REF: N165280

DATE: 18 October 2019

RE: ROYAL HALL OF INDUSTRIES, MOORE PARK – RESPONSE TO SUBMISSIONS

Figure 5.1: Loading dock and access arrangements

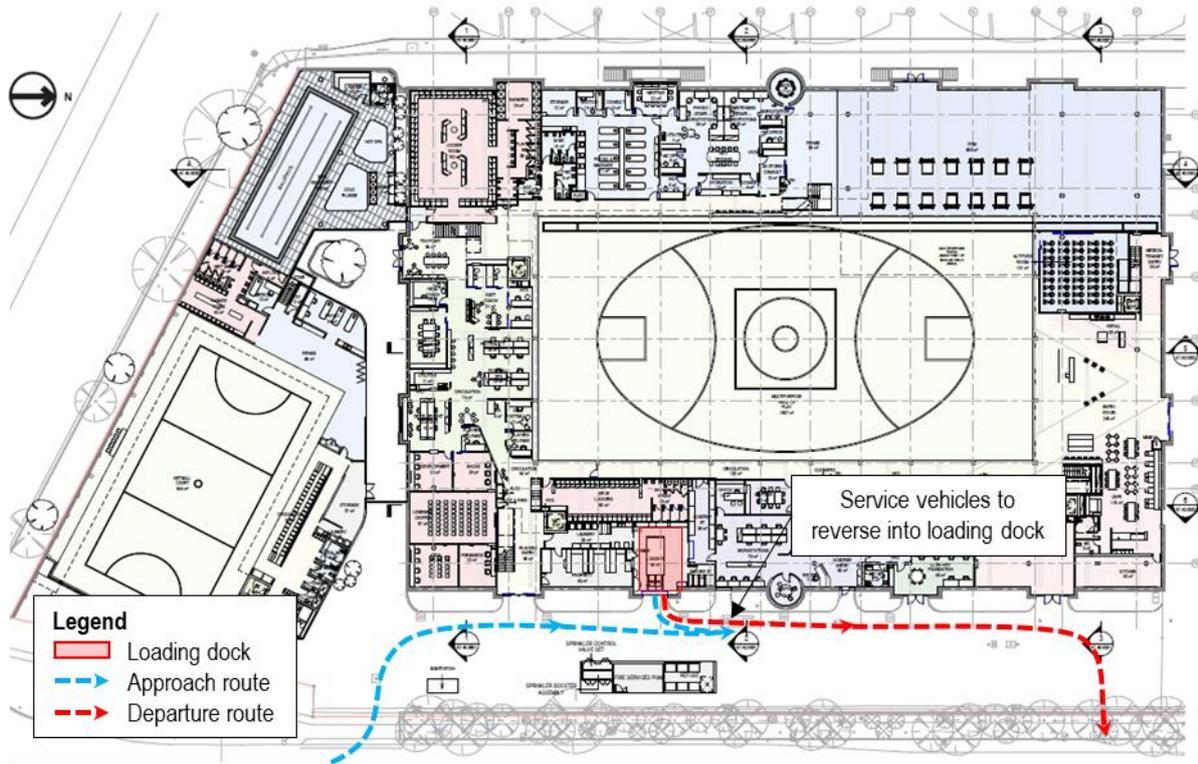
The EIS states that the proposed development includes a single loading bay suitable of accommodating small rigid vehicles up to 6.4 metres in length while the Transport Assessment report states that the loading bay would be suitable for all vehicles up to 6.8 metres. Nevertheless, the proposed loading bay size might limit future servicing of the site.

DRAWING NO. N165280-SK01

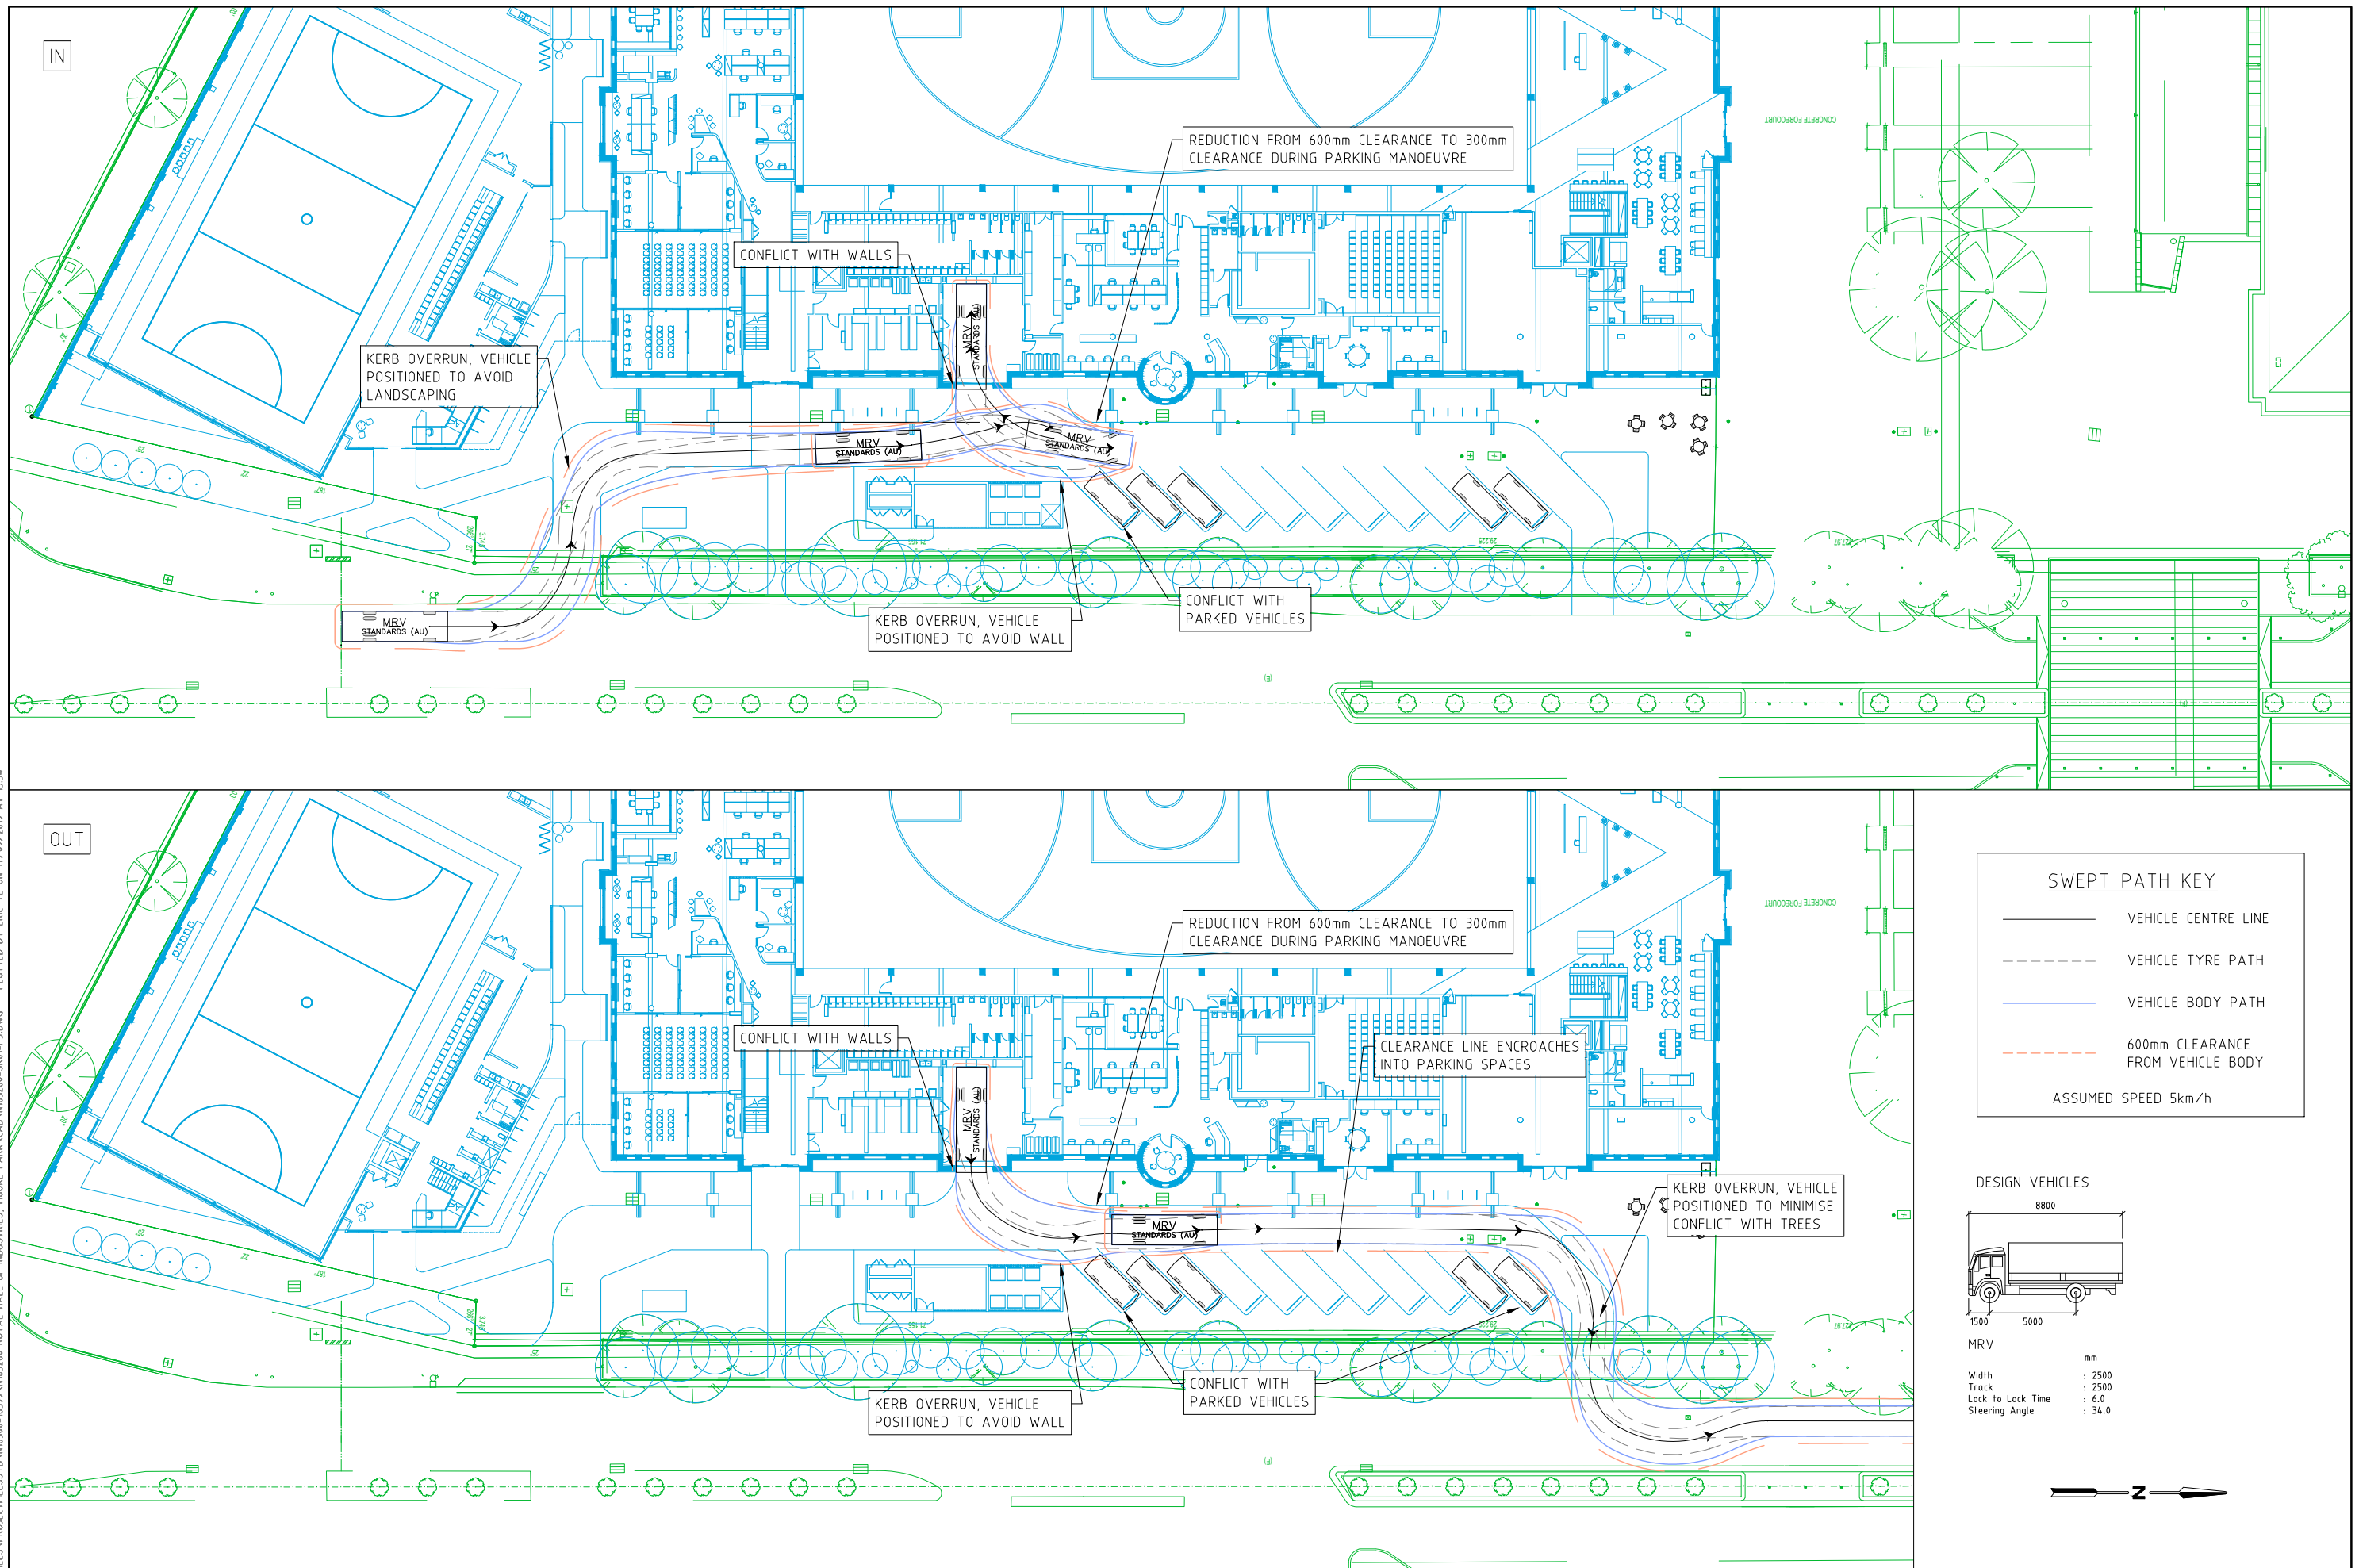
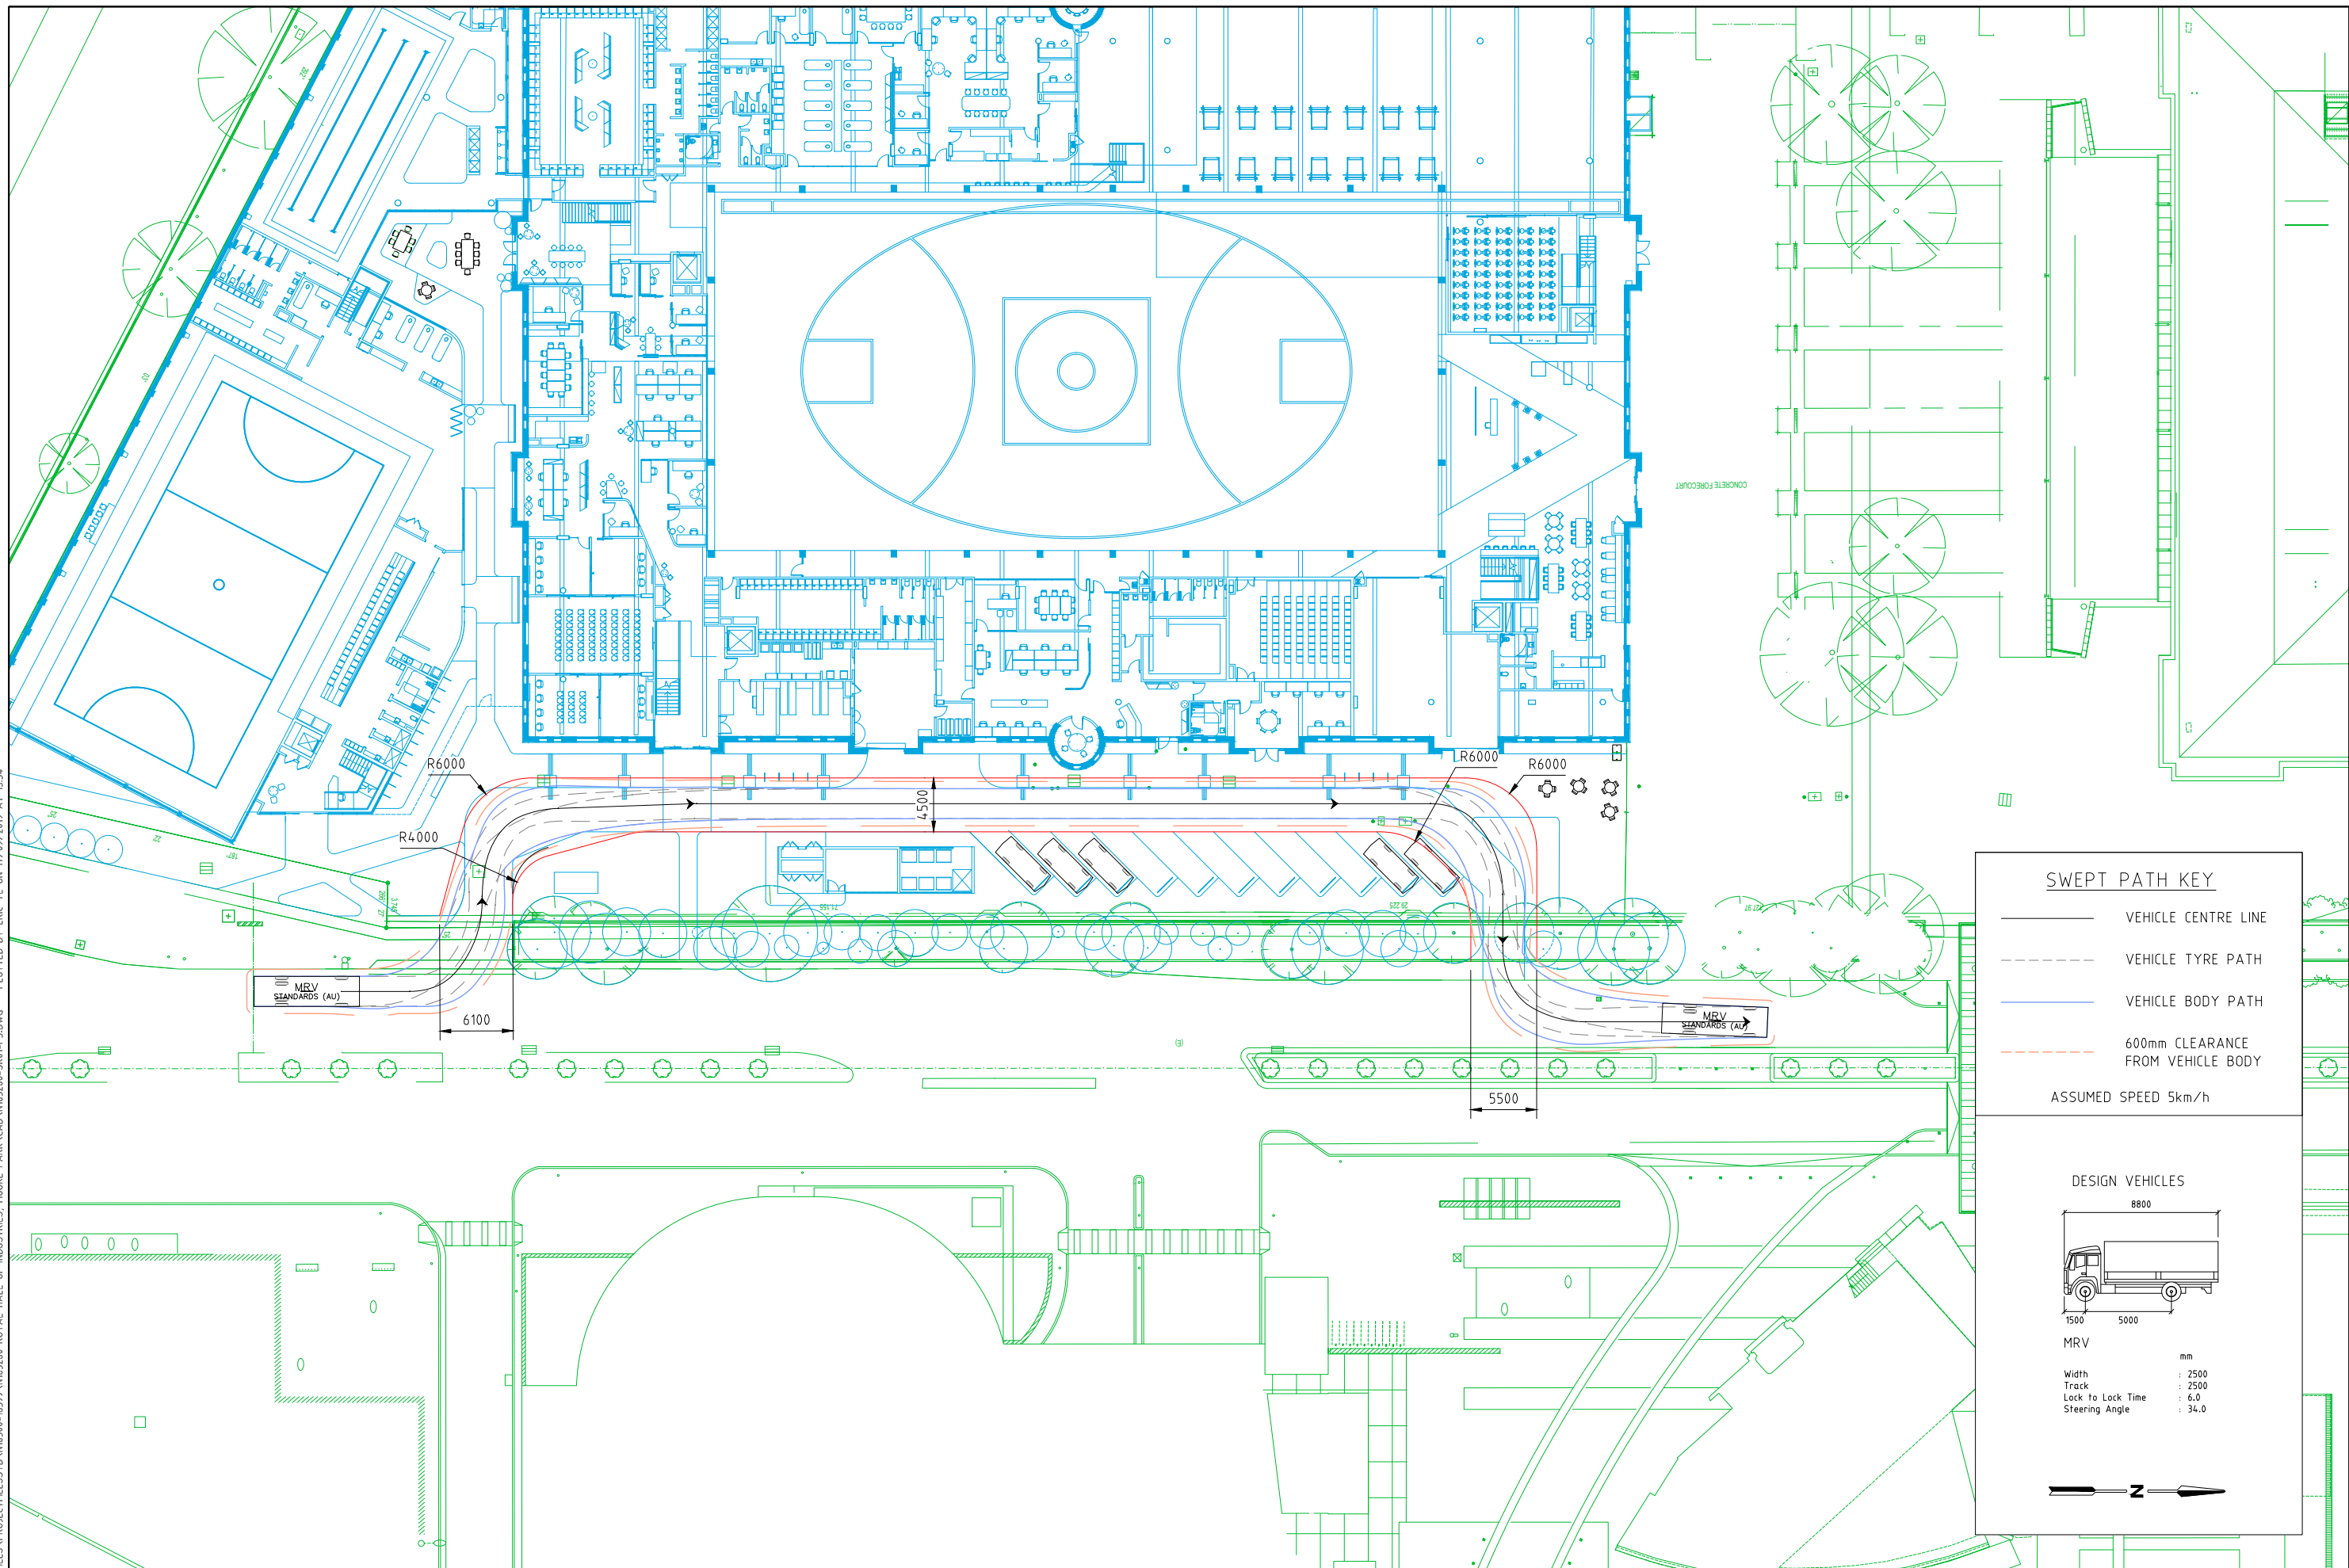
The EIS also states that the swept path analysis for service vehicles is contained within the Transport Assessment however it is not evident that such information has been included.

Notwithstanding the need to clarify the discrepancy between the two documents; an assessment of the size of vehicles likely to access the loading bay should be undertaken as part of the Response to Submissions with consideration of the future loading demand in relation to the proposed sport and community facilities.

Swept path analysis for service vehicle access should also be included in the Response to Submissions.

GTA response: Sydney Swans has advised that the largest size vehicle that currently services the Sydney Swans Headquarters is a 6.8 metre Volkswagen Crafter Runner. A swept path assessment has been

completed which confirms this vehicle is able to manoeuvre in and out of the site, including the loading dock.

Ausgrid also requires access to the site by vehicles up to 8.8 metre medium rigid trucks. These swept paths have been completed and the design modified to ensure all vehicles are able to enter and exit the site via Errol Flynn Boulevard in a forward direction. This also ensures seven to eight metre long minibuses will be able to access the site, if required.
